From: Maria Tomalova
Sent: 19 January 2022 16:33
To: [REDACTED]
Subject: LU/397/21/DOC

LU/397/21/DOC
The Farm 39 East Street Littlehampton BN17 6AU

Approval of details reserved by condition imposed under LU/134/21/PL relating to conditions 3- details of the new external doors and windows including sections and their treatments along with details of new porches; 4-details of proposed removal of existing unsympathetic modern windows and their replacement and re-use of existing traditional windows; 5-all new internal joinery such as doors and skirting boards; 6-details of proposed location, heights, materials and finishes of boundary treatments & 9-on site cycle parking storage.

Cellar, Ground Floor and First Floor Plans -
Proposed
Discharge of Conditions

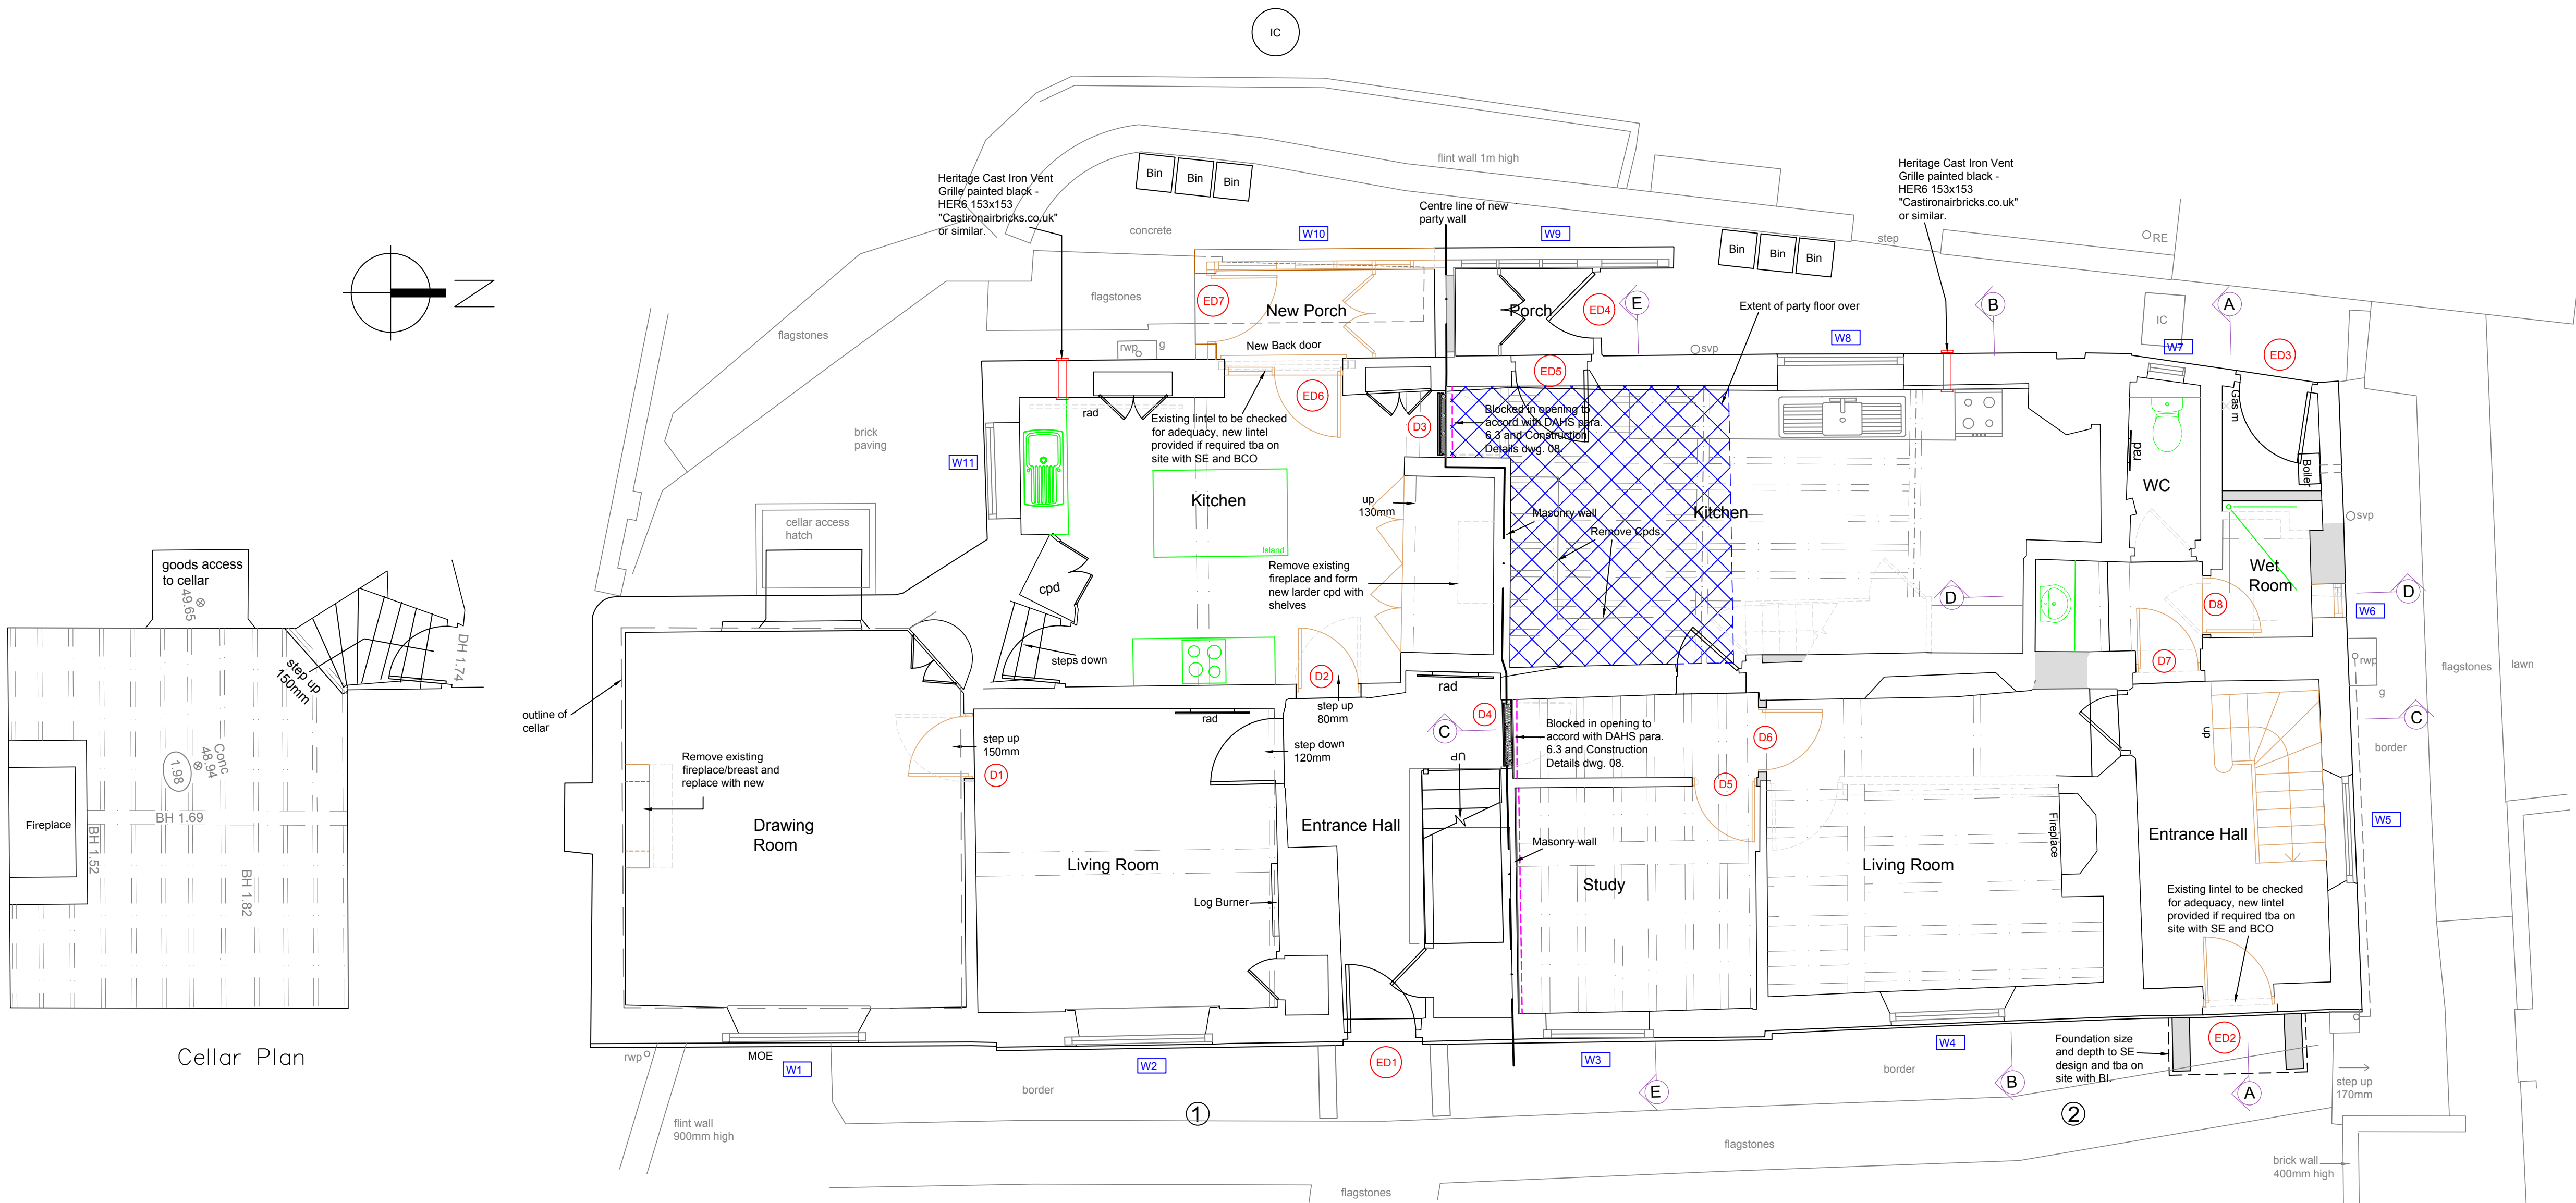
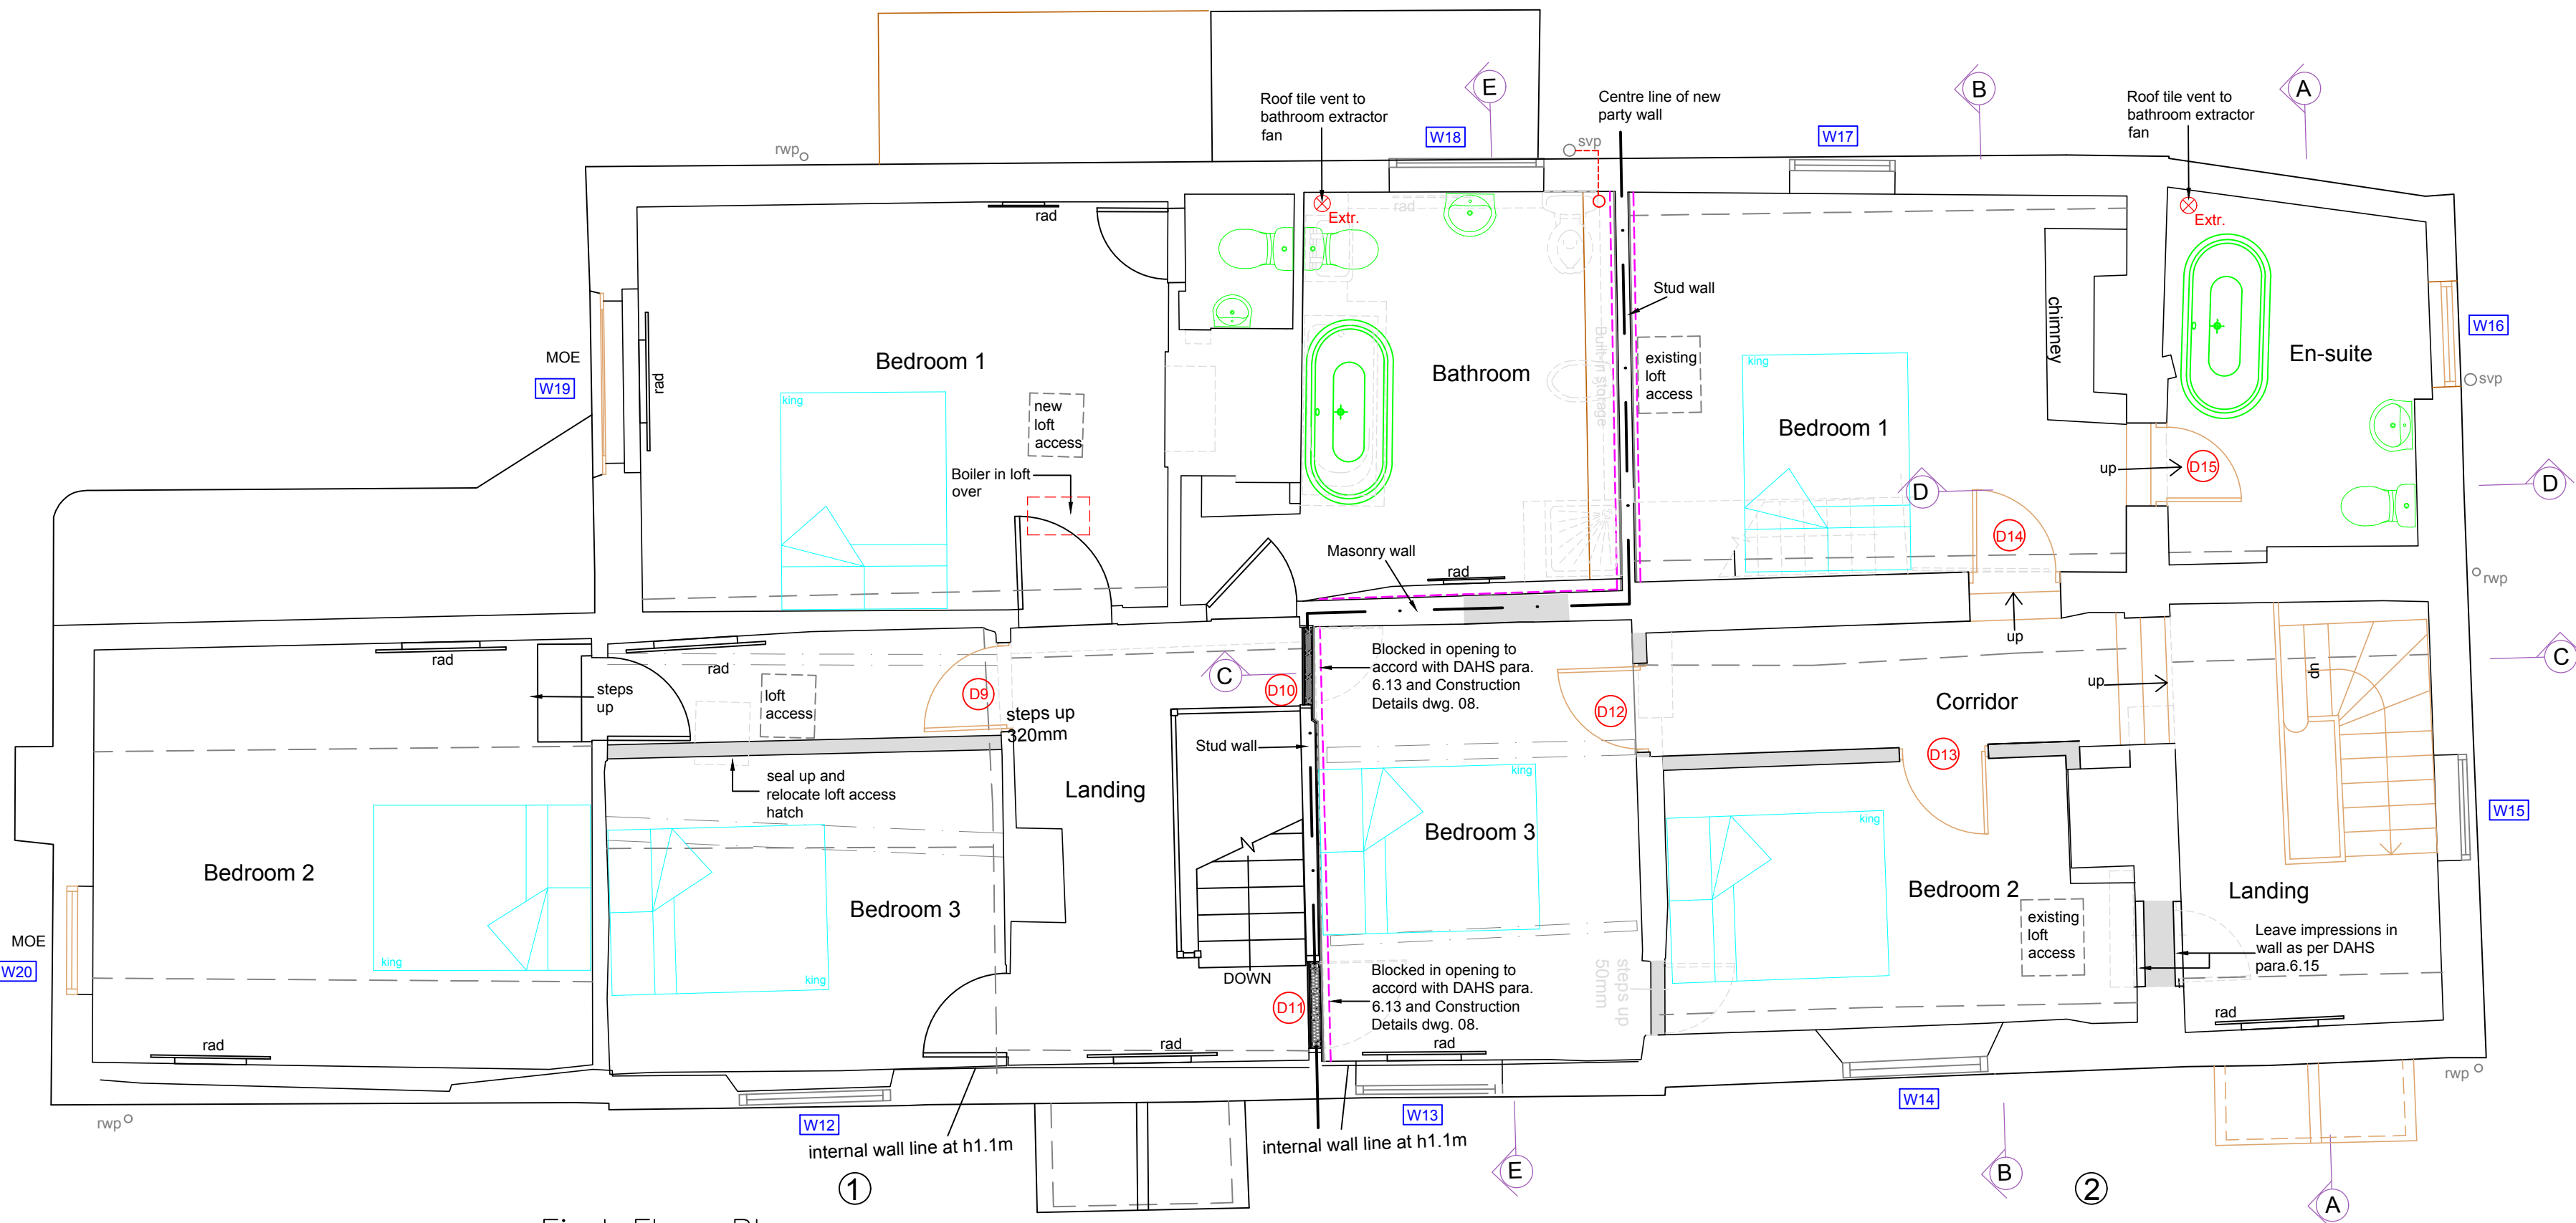
Conditions 3 & 4 – I am unable to locate the section of the windows in unit 2: GF W6 and FF W16. The statement indicates that FF W16 will match the existing FF window on the same elevation. However, this is not fully clear from the drawing of the front elevation only. Further, I am unable to see an information regarding the window for the new porch W10 or the replacement window/door identified as ED6.

Furthermore, it is not clear if any works are planned to take place to W1. This needs to be clarified.
